NORTHAMPTON  
**GATEWAY**  
STRATEGIC RAIL FREIGHT INTERCHANGE

**STATEMENT OF COMMON GROUND BETWEEN  
THE APPLICANT AND HIGHWAYS ENGLAND**

**DOCUMENT 7.1D**

### Further Statement of Common Ground with Highways England in relation to transport matters and the draft Development Consent Order

**Drawing Title**  
 MAIN SITE  
 DRAINAGE STRATEGY

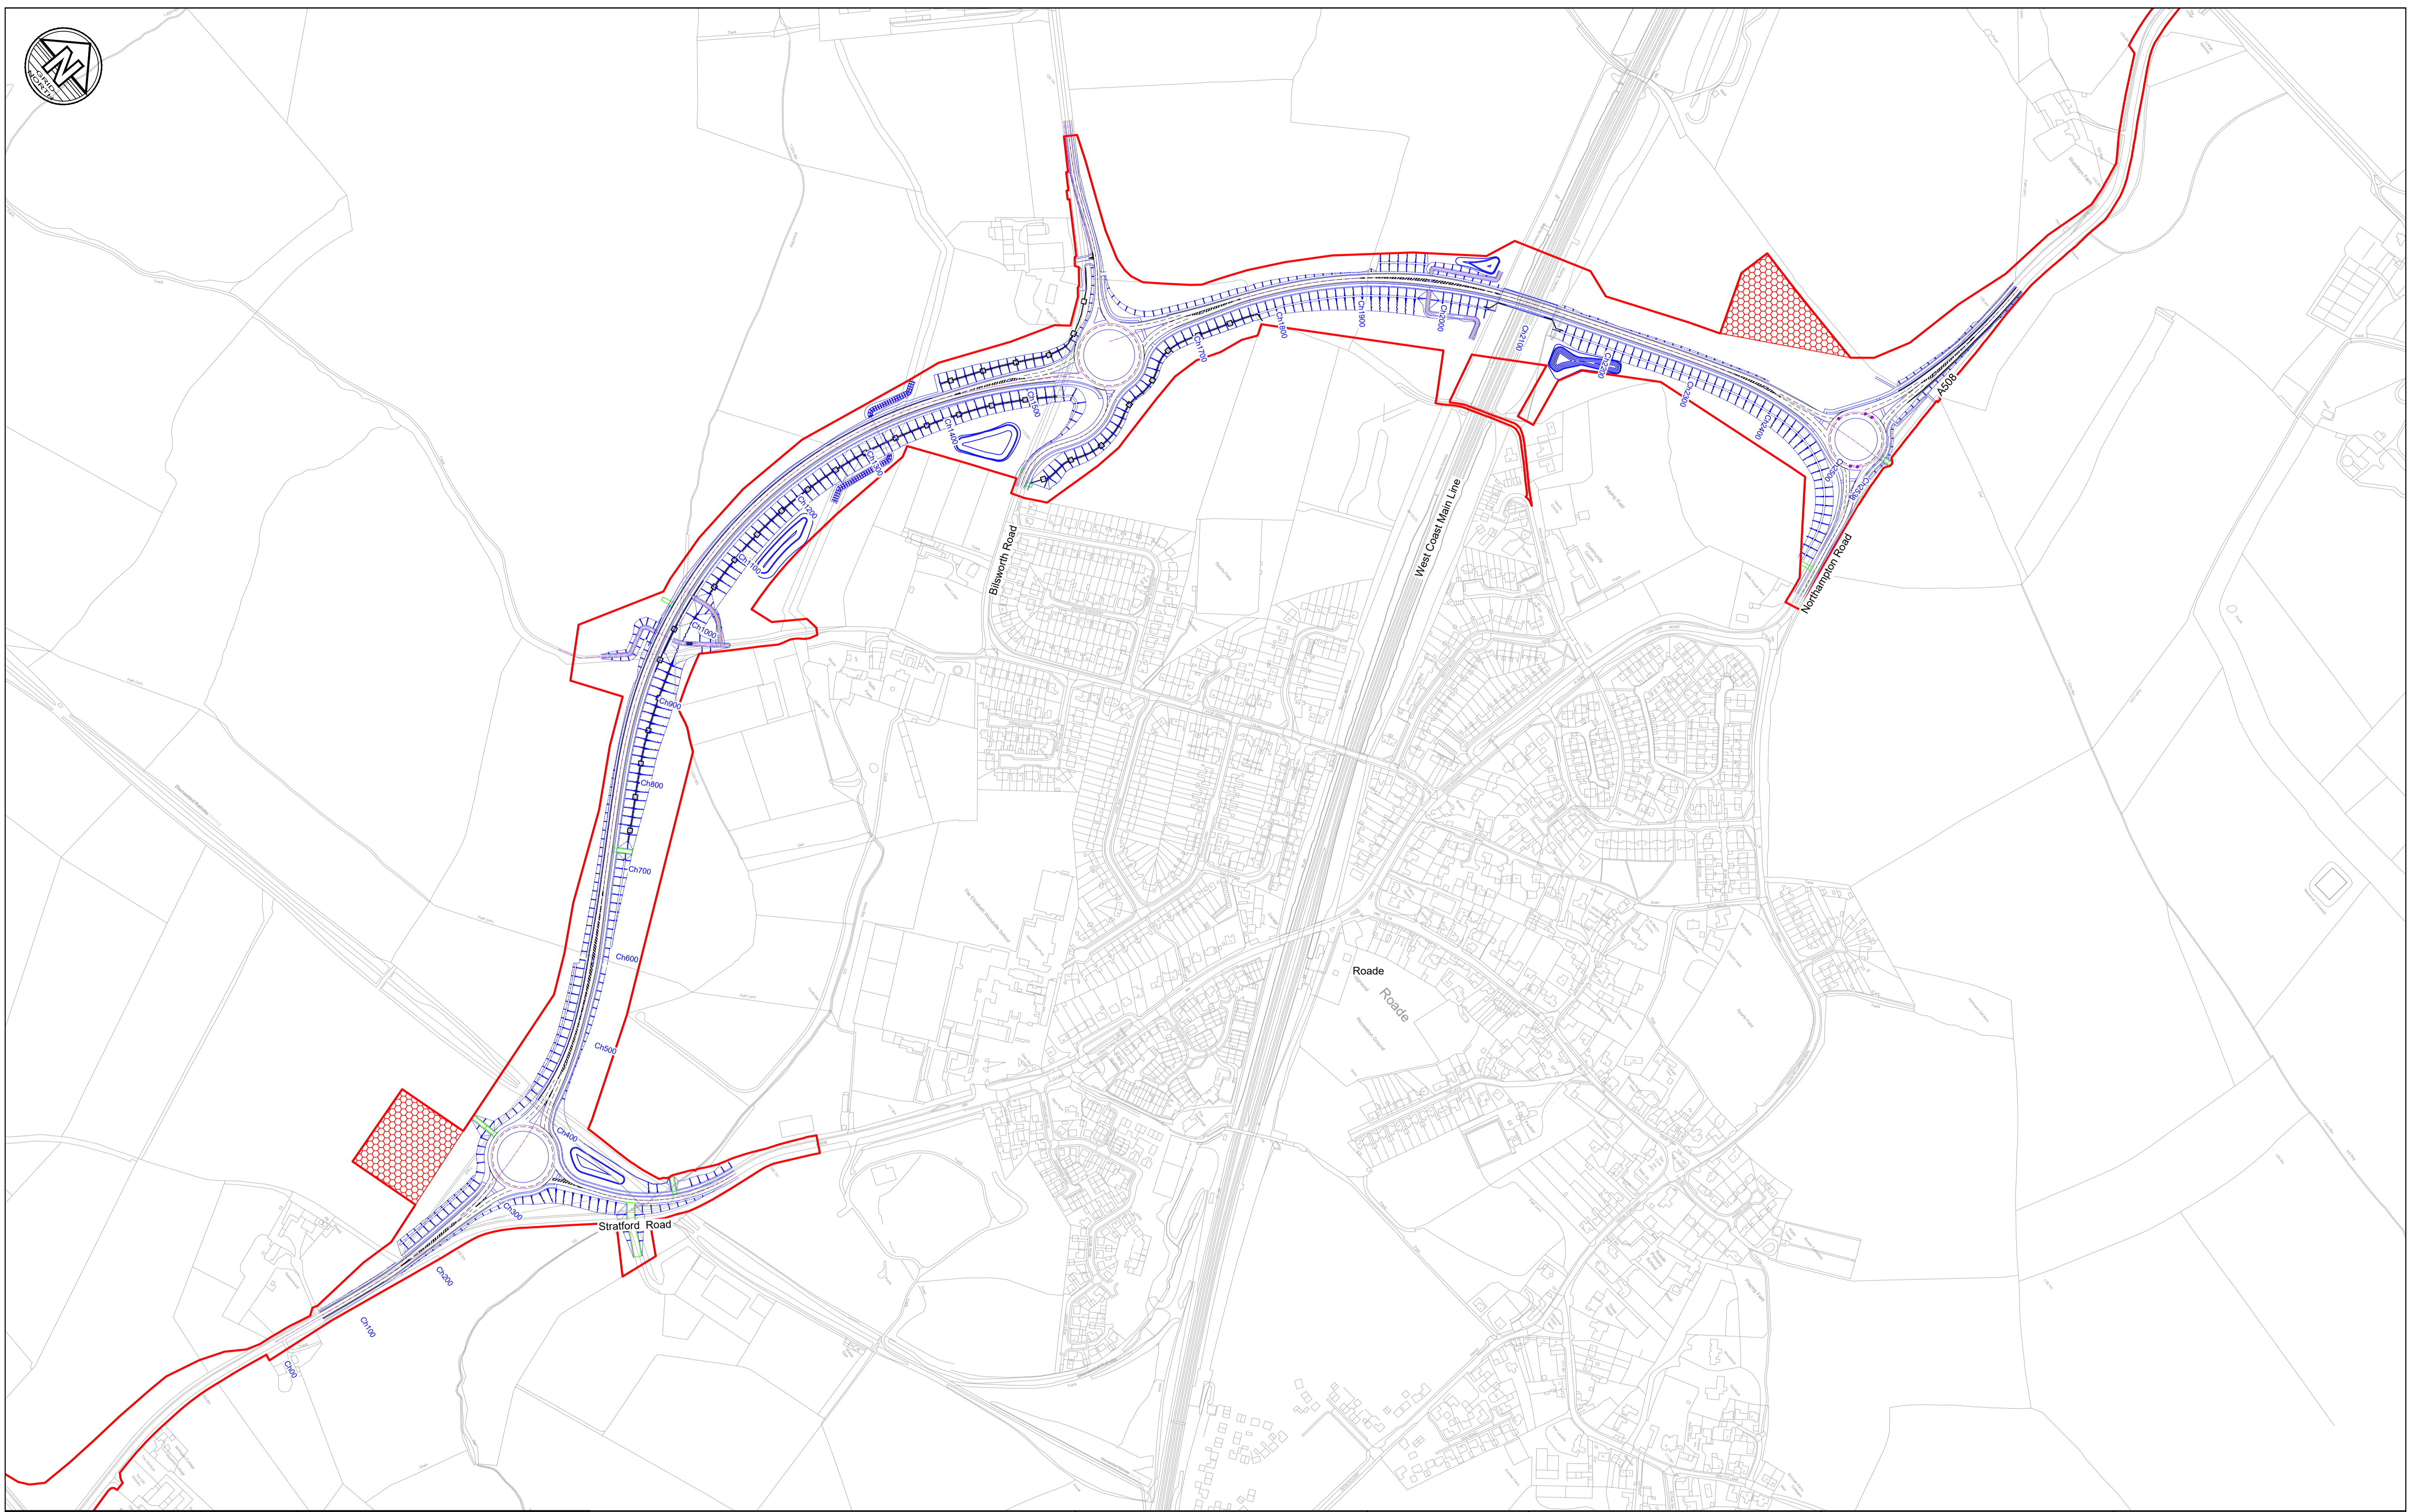
- 1) At Collingtree, the culverted watercourse is a 300mm diameter pipe that passes beneath the M1. The drainage strategy (which has been agreed with Northamptonshire Council County as lead local flood authority, LLFA) confirms that the flow into this watercourse, which is a culverted watercourse under the M1, will not increase as a result of the development. Hence there will be no impact on the existing culvert and the connection into the existing watercourse will be made upstream of the M1 boundary. This satisfies the risk of additional flows to the Highways England network. Therefore, the only increased risk to Highways England is through riparian responsibilities in terms of allowing free passage of water should a blockage occur, and the existing culvert will be cleared out and jetted if necessary as part of the highway works.

2.6 The principles of the SRFI main site drainage strategy, in so far as to how they may impact the strategic road network, are therefore agreed with Highways England.
